From: Gavin Cherry
Sent: Tuesday, 20 March 2018 12:41 PM
To: Bianca Thornton
Cc: Simone Vella
Subject: Final Further Submission to the NSW Department of Planning - Sigma Pharmaceuticals Warehouse and Distribution Facility (SSD 7719 MOD 1)

Figure 7 – Comparison of Landscaping at North East (NE) Corner

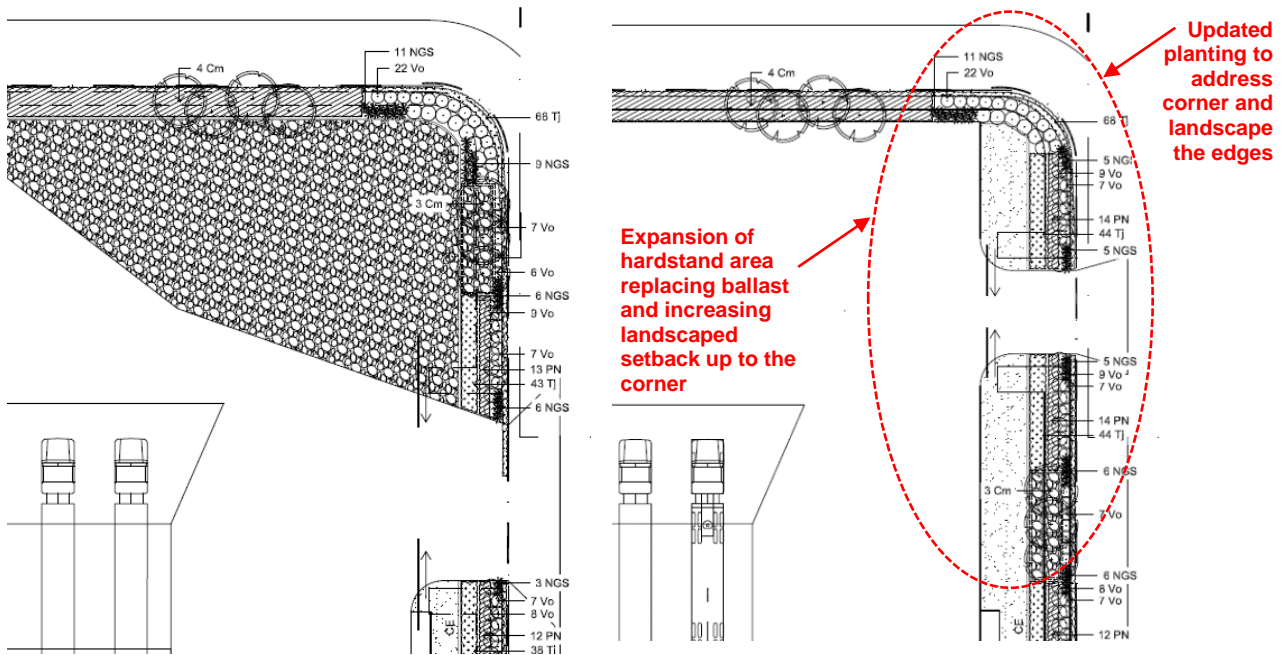
As discussed this morning, while Council does not object to the proposal, the submission response does not suitably resolve the issue regarding the landscape treatment of the site at the road intersection. The corner treatment proposed is substantially different to that which was approved as this area was previously not trafficable. The turning paths indicated appear to exaggerate the manoeuvring requirements of the vehicles which would suggest that landscaping can be provided for the extent identified on the previously emailed diagram.

I would again ask that the Department address this in the determination of the application (such as conditions of consent) if the above suggested amendments are agreed with and deemed reasonable.
